## S278 AGREEMENT WORKS

### MERAKI ALLIANCE: STAGE I ROAD SAFETY AUDIT.

**RESPONSE DATE: 05.06.26**

Date: APR 26  
 Scale: 1/200 @A0  
 Dwg No.: E25/8392/040A

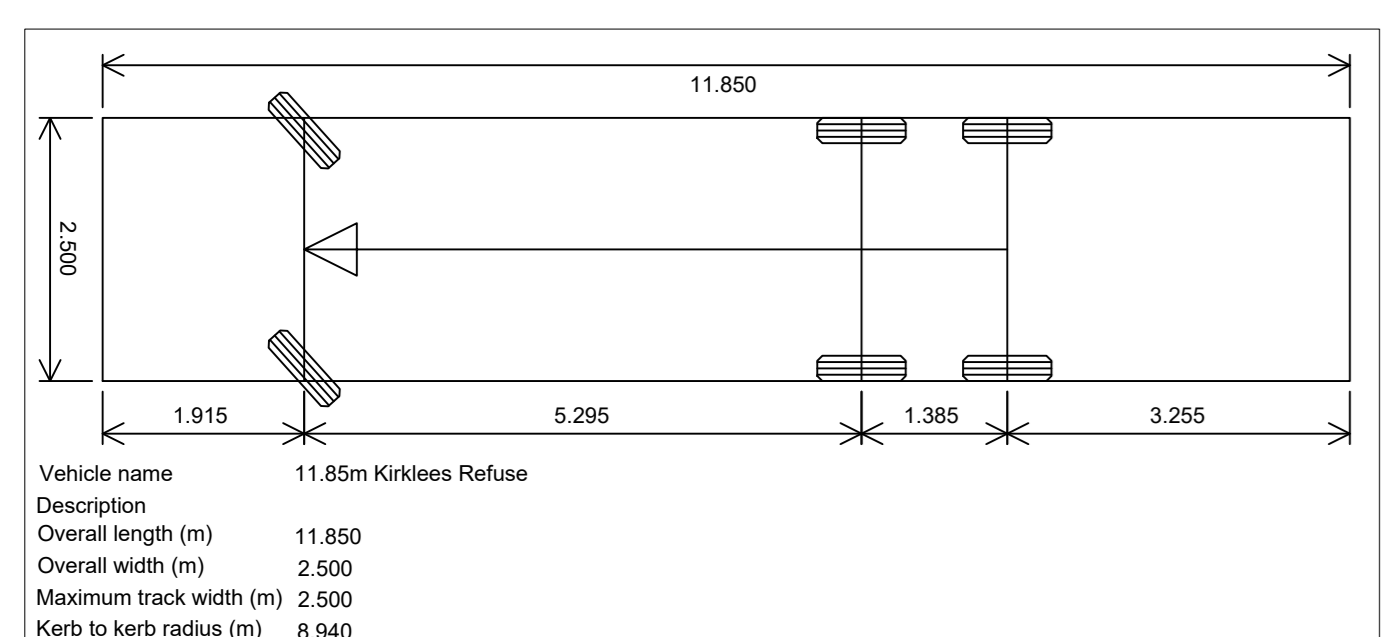
2.1	<p><b>Location:</b> General to scheme  <b>Summary:</b>            Drivers could become confused if old road markings are not fully removed before the new markings are implemented</p>	<p>Ensure the existing carriageway markings are fully removed or that the carriageway is resurfaced.</p>	<p>Key added to dwg. 8392_040A to show existing road markings to be removed.</p>

2.1	<p><b>Location:</b> Proposed development access  <b>Summary:</b>            Increase in cross path collisions or pedestrian collisions, due to obstructed visibility.</p> 	<p>Ensure that the visibility splay is achieved and is kept free of obstructions, in perpetuity by undertaking site clearance.</p>	<p>Dwg. 8392_040A shows 2.4m x 40m Visibility Splay achieved, with no obstructions.</p>
